Application for a non-material amendment following a grant of planning permission.

Resubmission of planning application relating to design amendments to planning permission 3/2017/0674 in connection with the construction of four dwellings including associated drives, gardens and external landscaping works.

Reference number:	<input type="text" value="3/2018/0344"/>
Date of decision	<input type="text" value="24/05/2018"/>

update to window fenestration to plots 1, 2, 3 and 4.

**5513 - P02D**

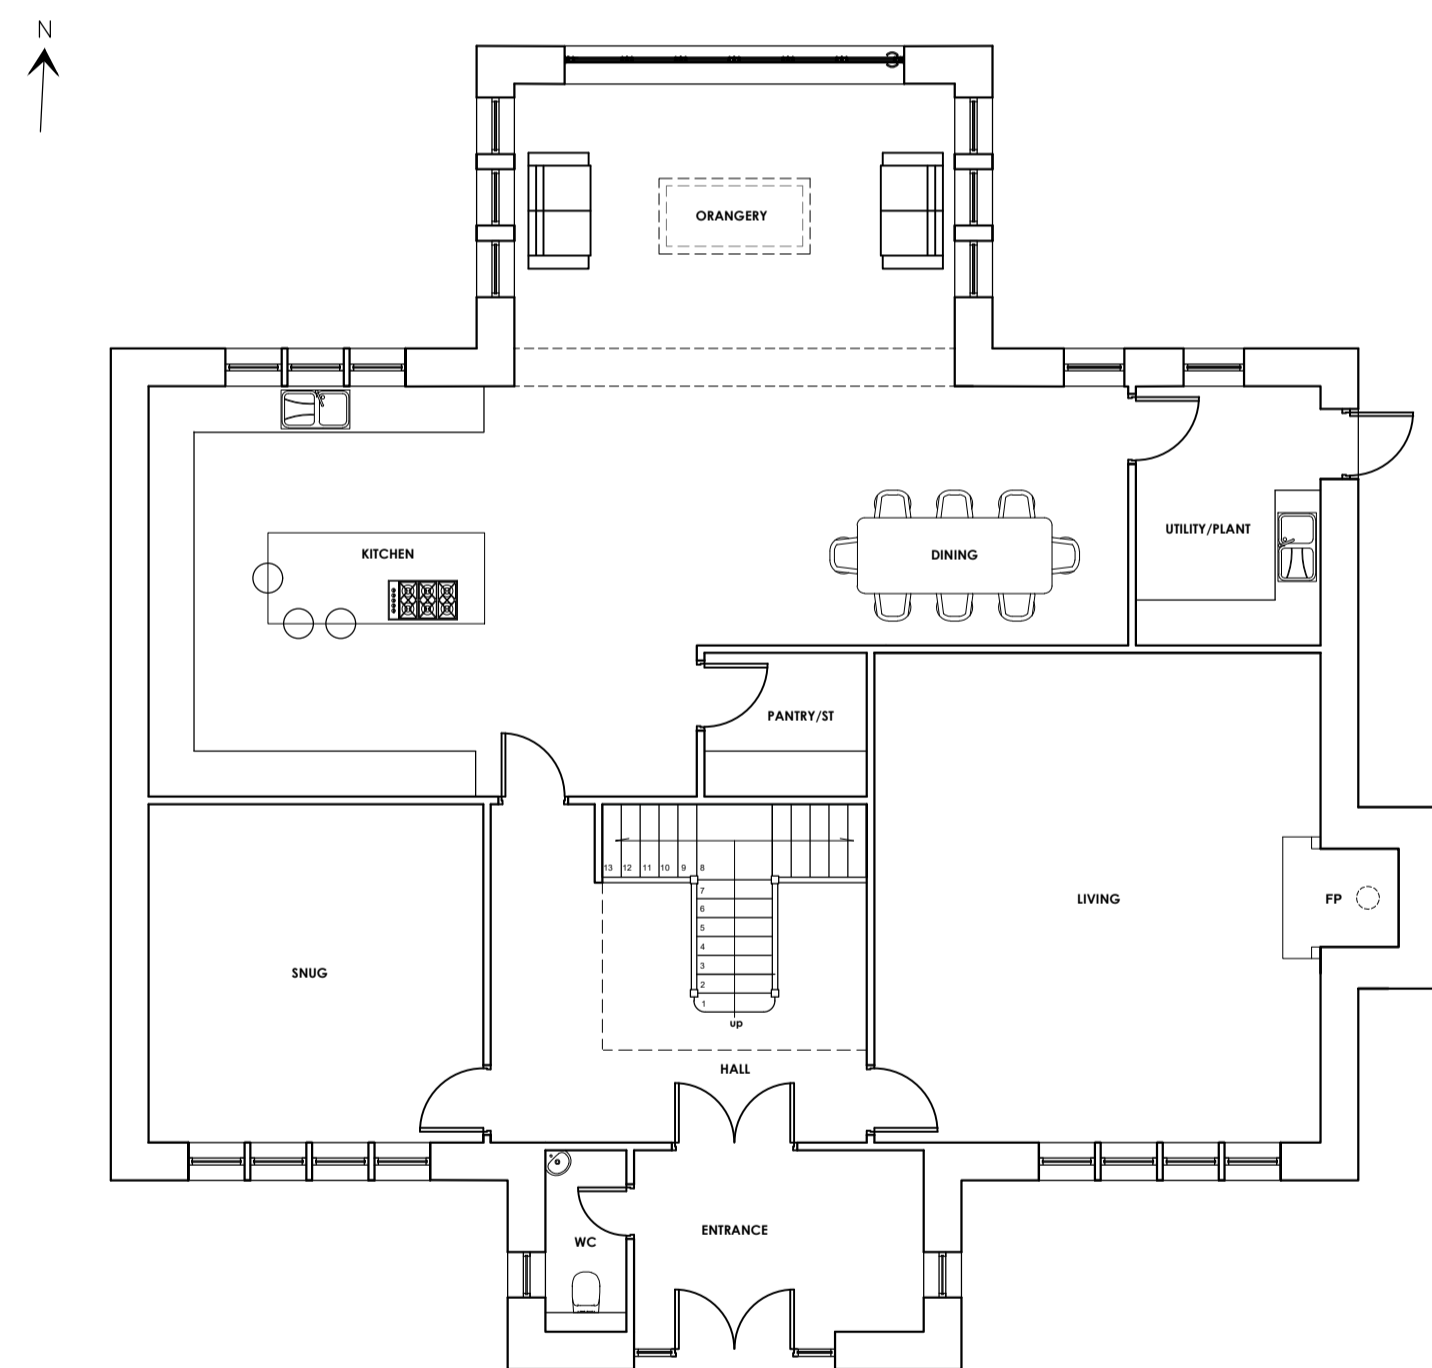
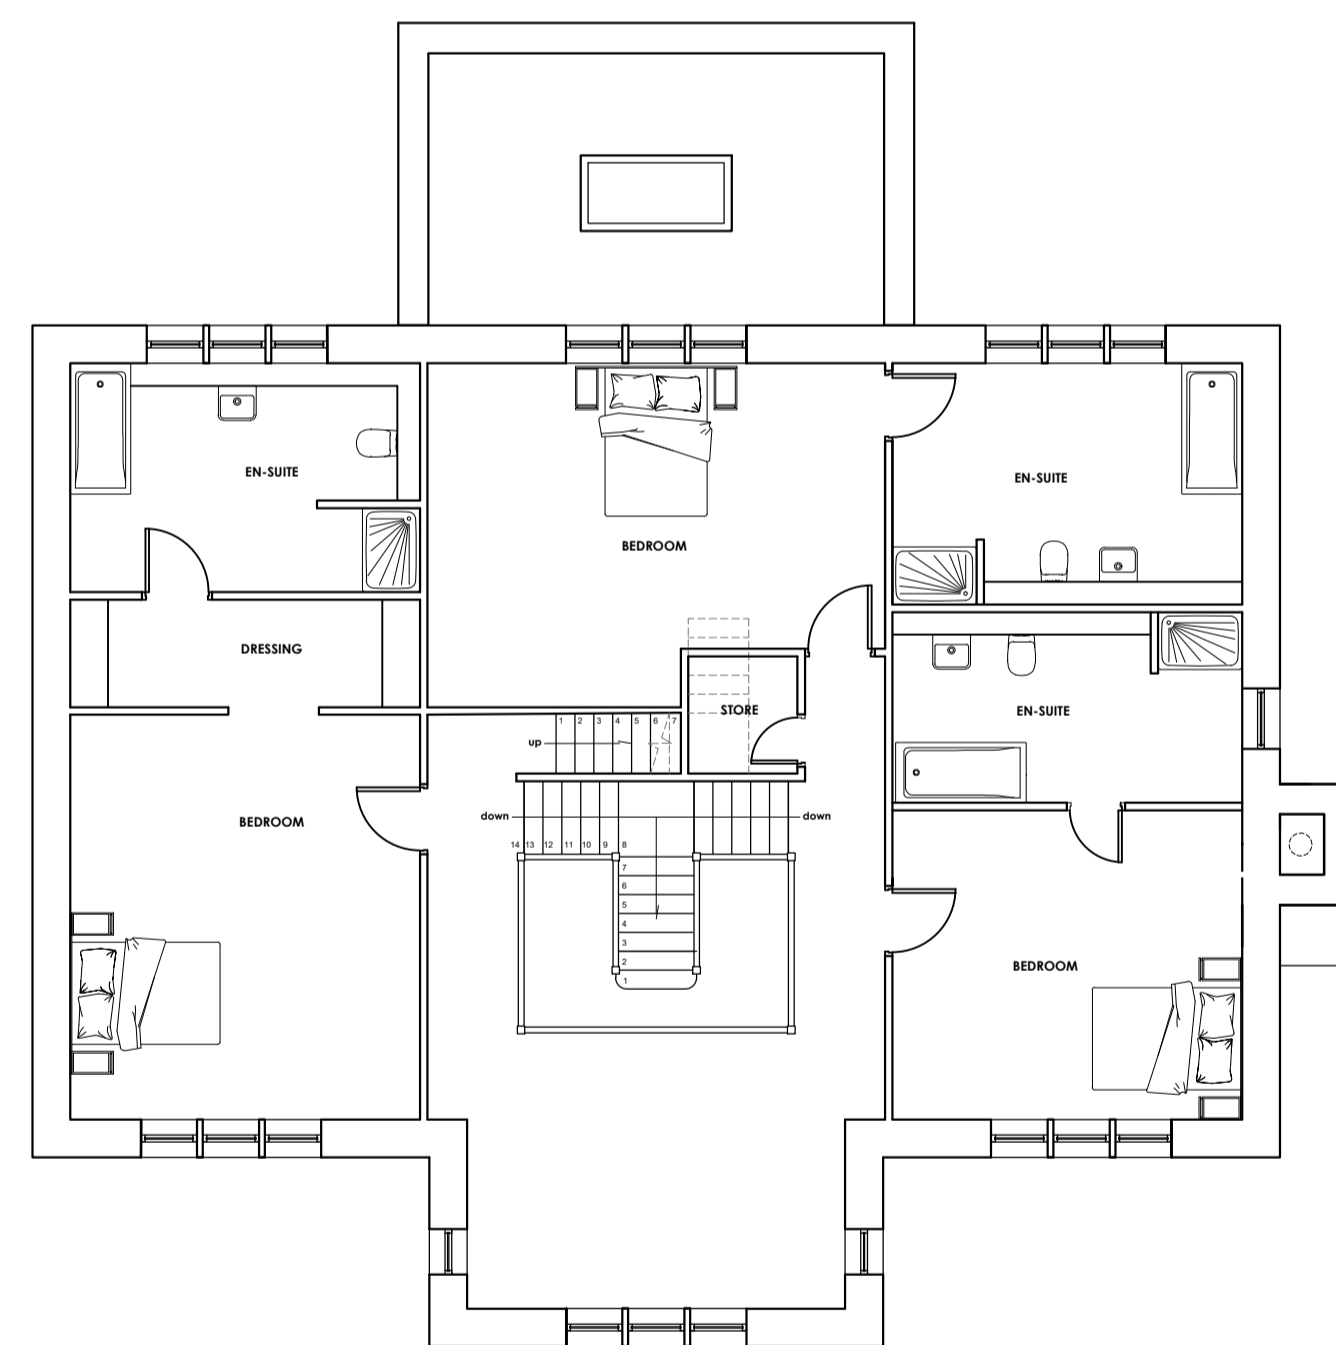
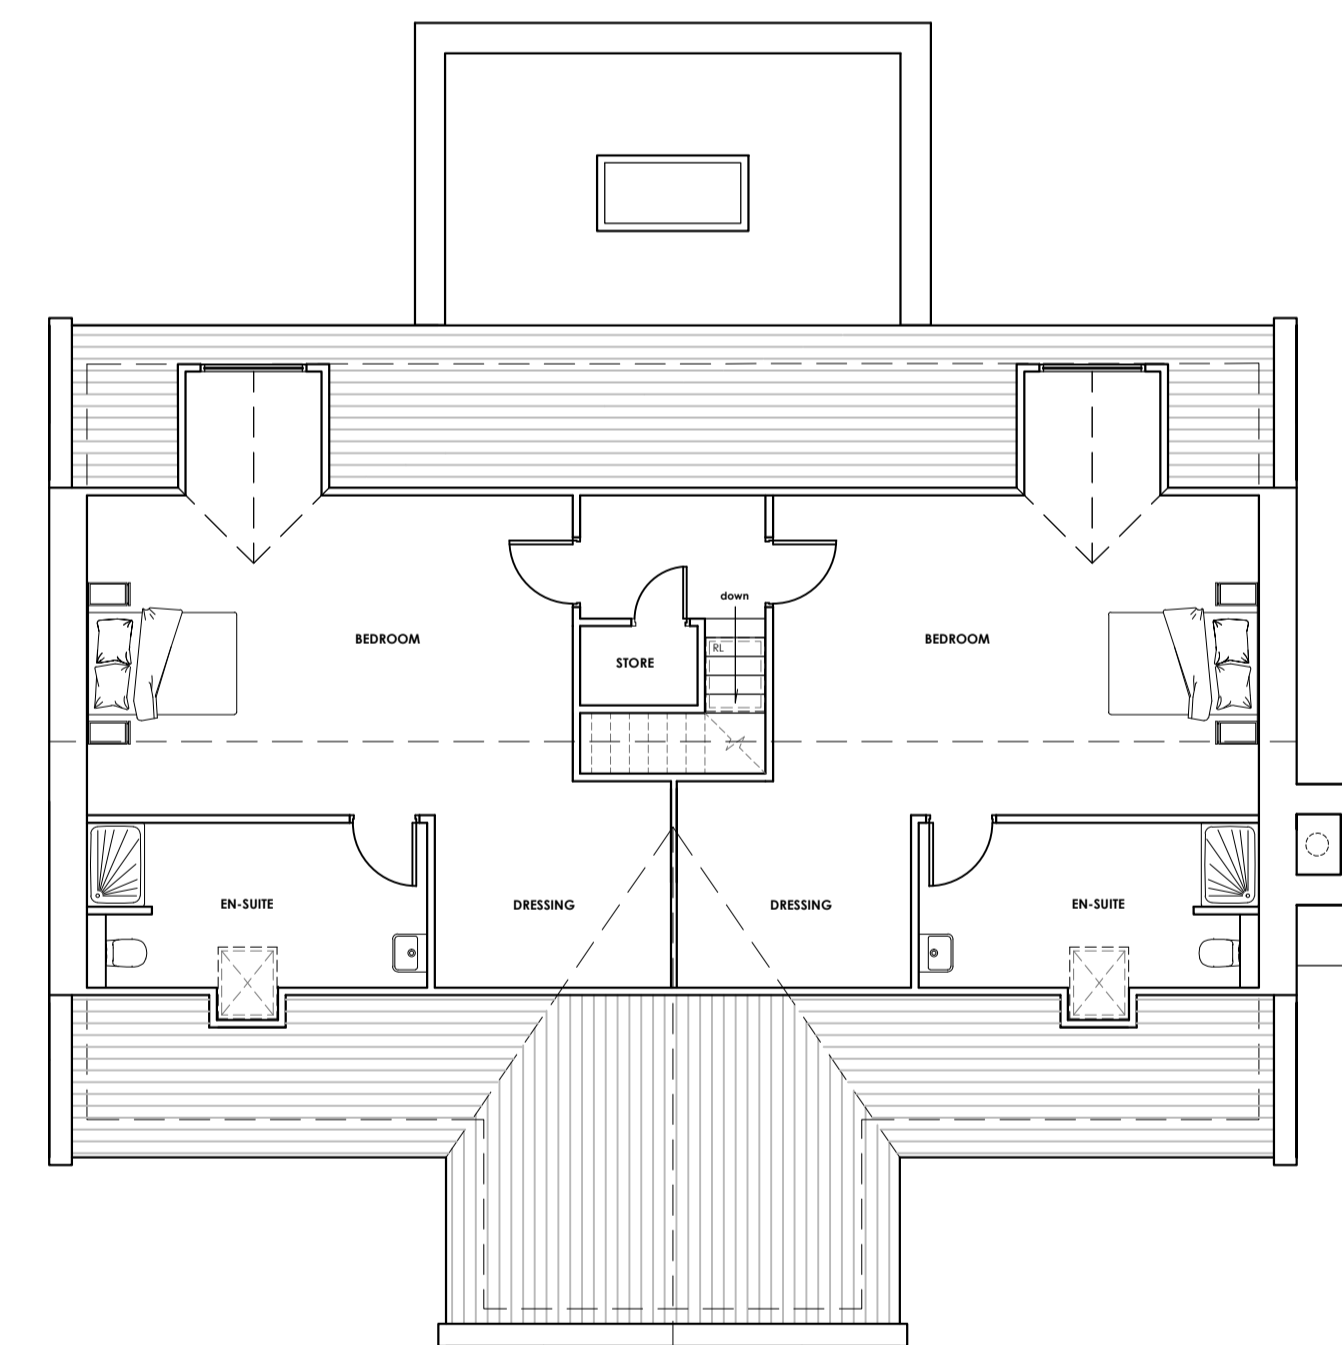
5513-P01B
5513-P02C
5513-P03C
5513-P04C

5513-P01C
5513-P02D
5513-P03D
5513-P04D
